SSD-61775465
D157/24
JD6 (CPE)

Re: STATE SIGNIFICANT DEVELOPMENT – REQUEST FOR ADVICE

SSD-67175465 – Mod 3 – 173 Walker Street North Sydney

DRAWING NAME:
SITEWORKS AND STORMWATER
MANAGEMENT PLAN,
SHEET 3

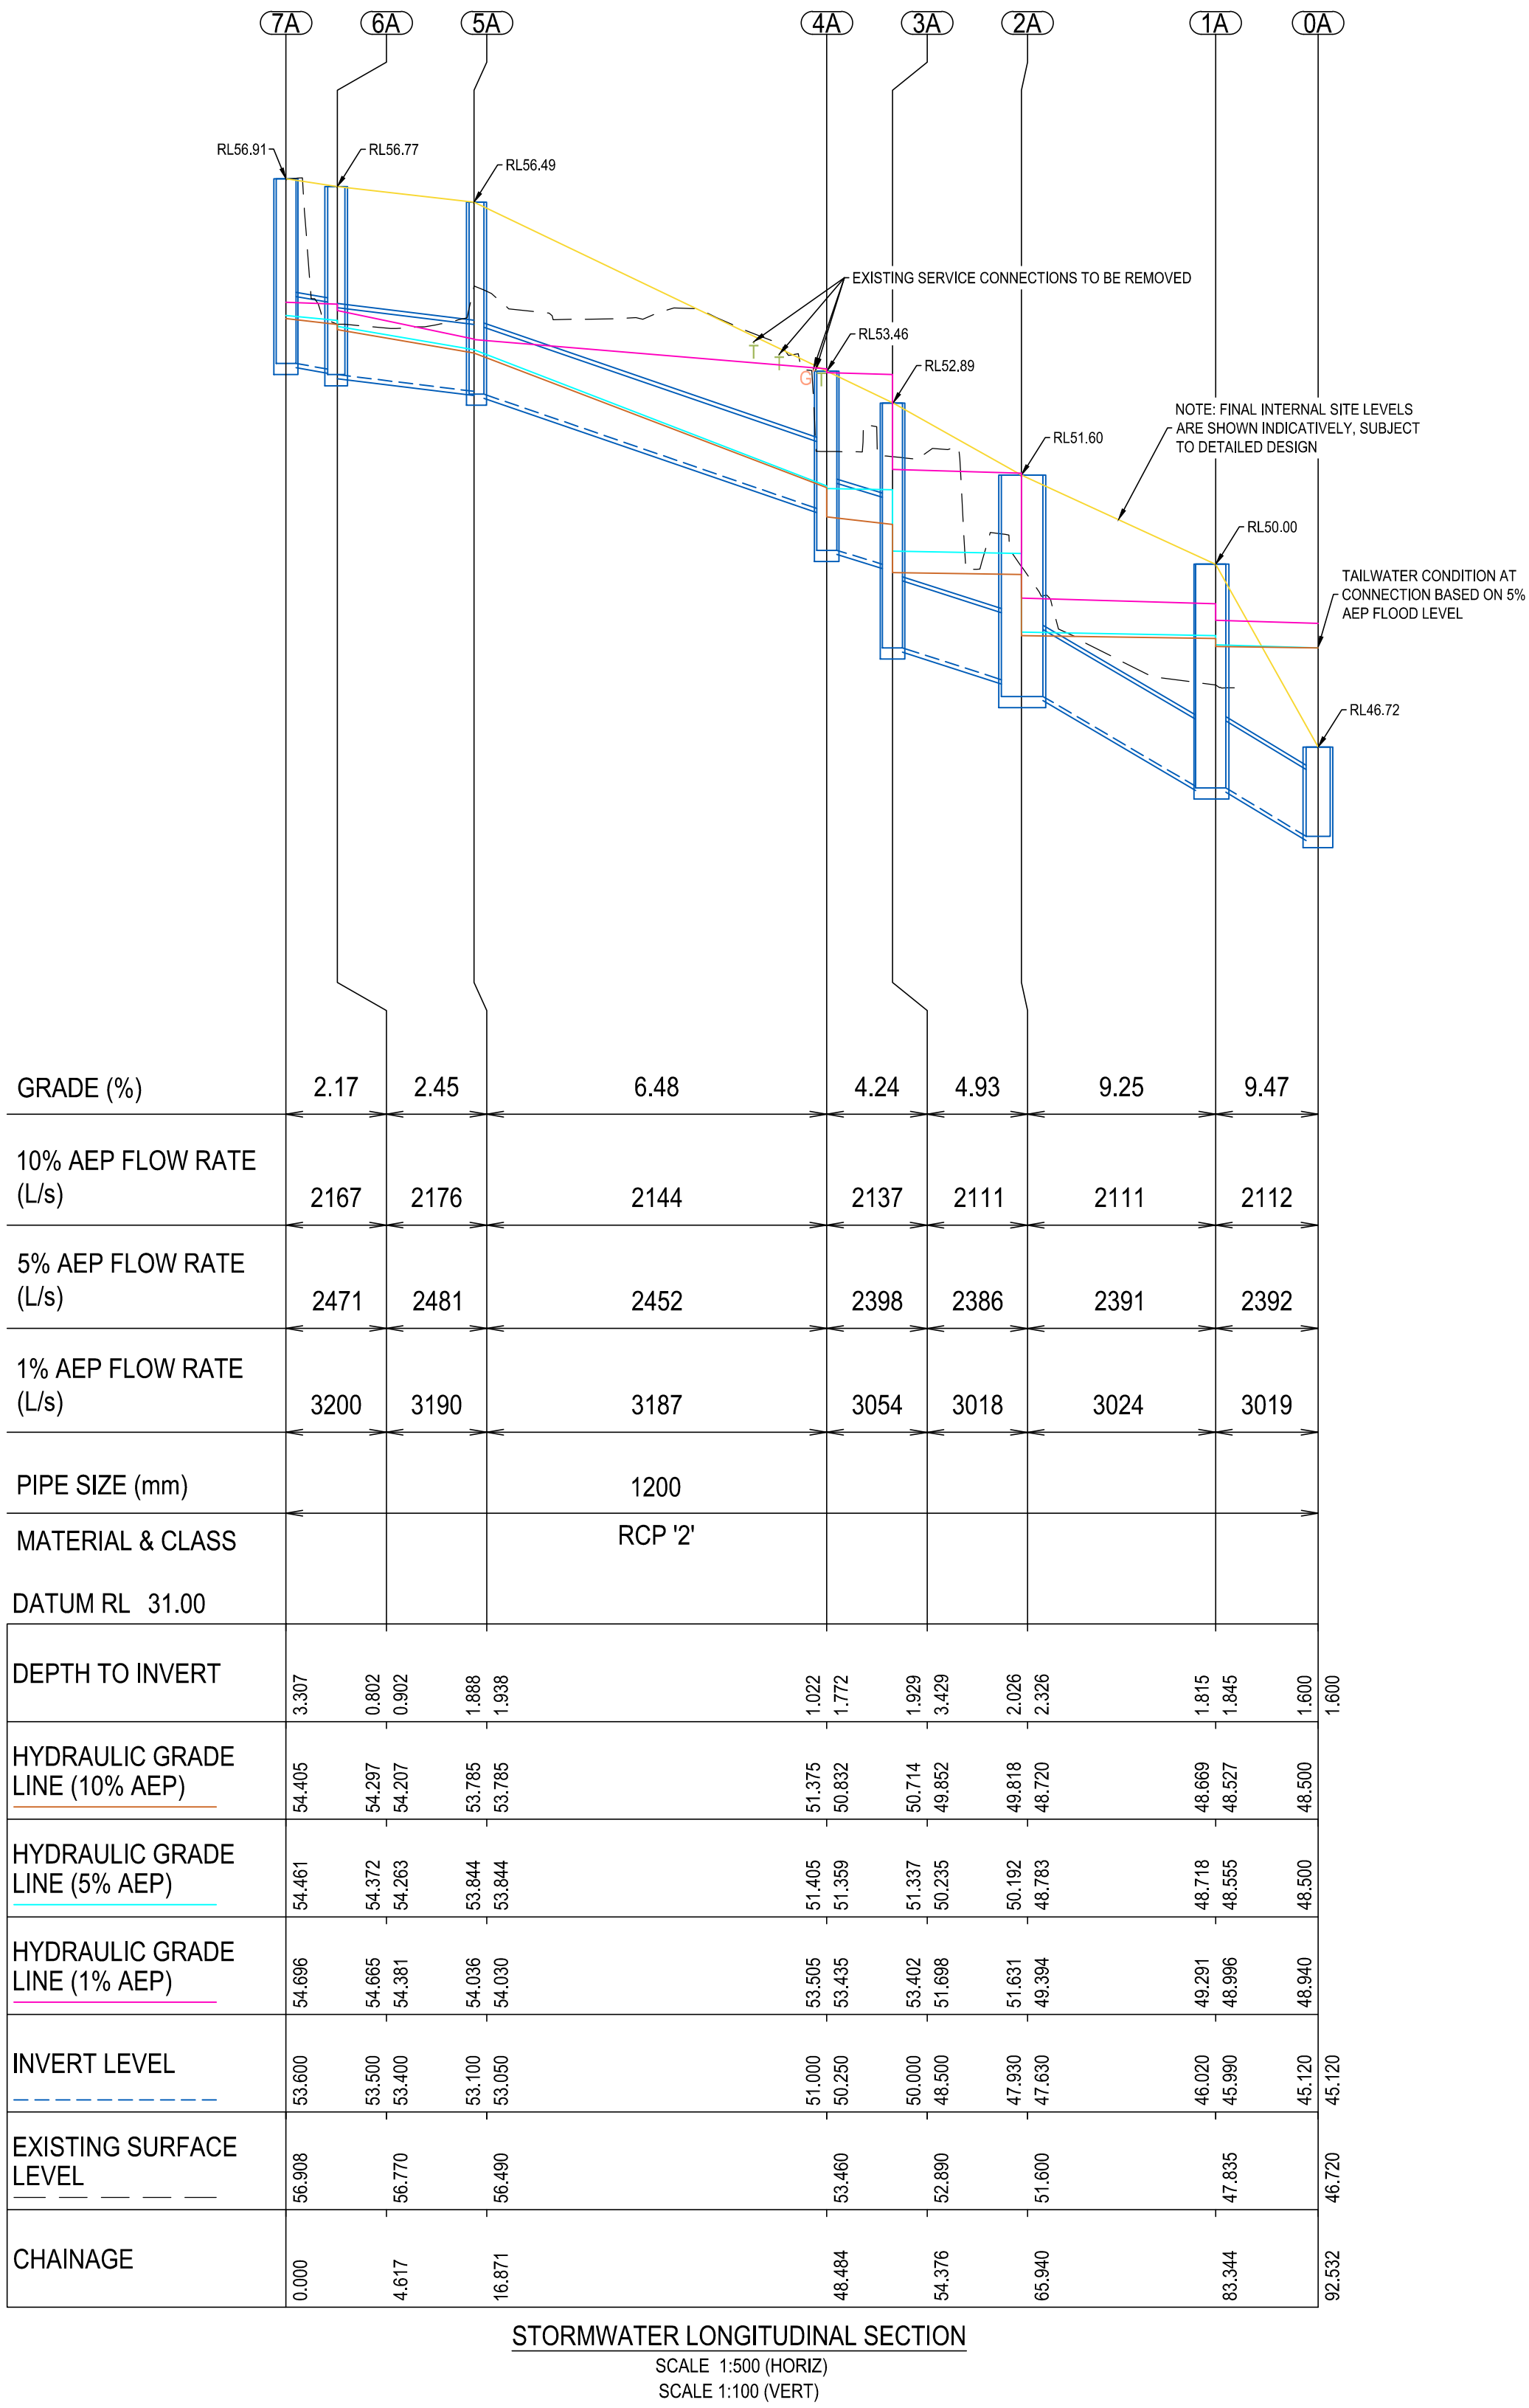
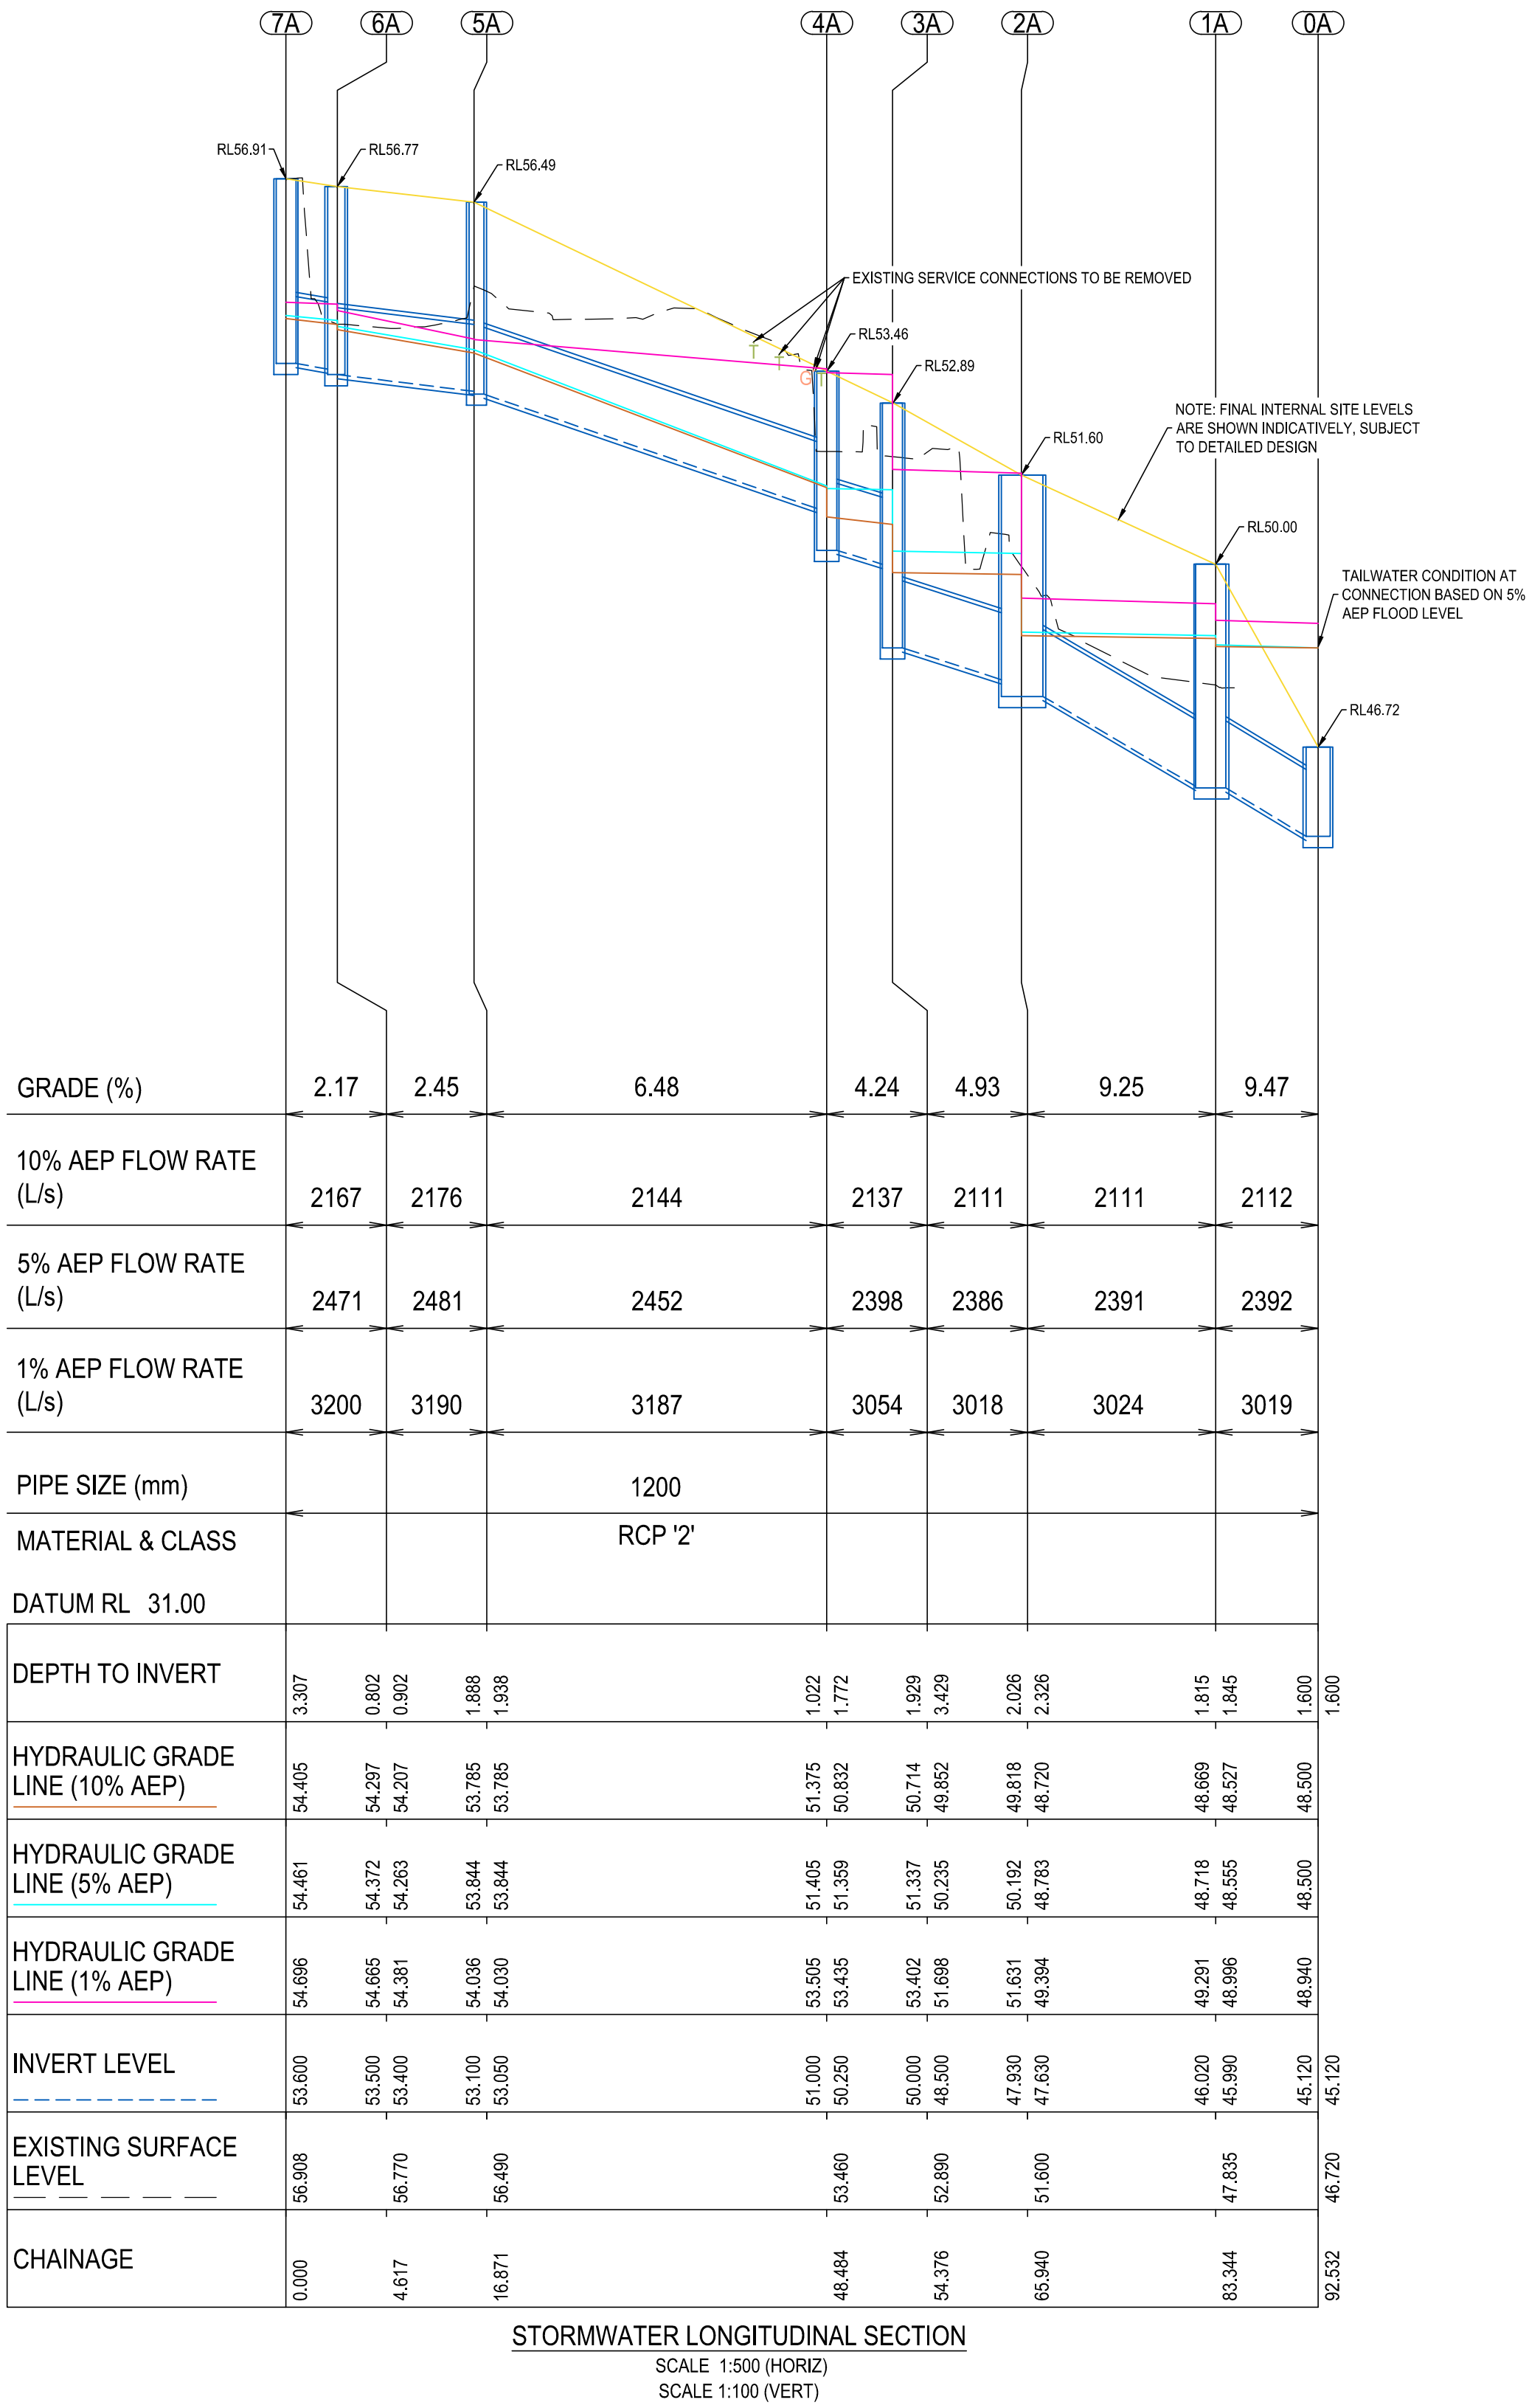
3. The applicant was also informed that Council would require at least 800mm clearance from the basement walls to the stormwater pipe, to allow replacement of the pipe in the future and that any cantilever of the building would need to provide enough space to allow the pipe to be replaced if needed.

4. Additionally, the pipe is to be clear of all structures. The modifications submitted do not reflect these requirements and will make future maintenance and replacement more difficult and result in additional expense for Council.

5. Further, neither does Council support replacement of the kerb inlet pits with strip drains in Hampden Street, as strip drains are more likely to be blocked and create future maintenance difficulties for Council.
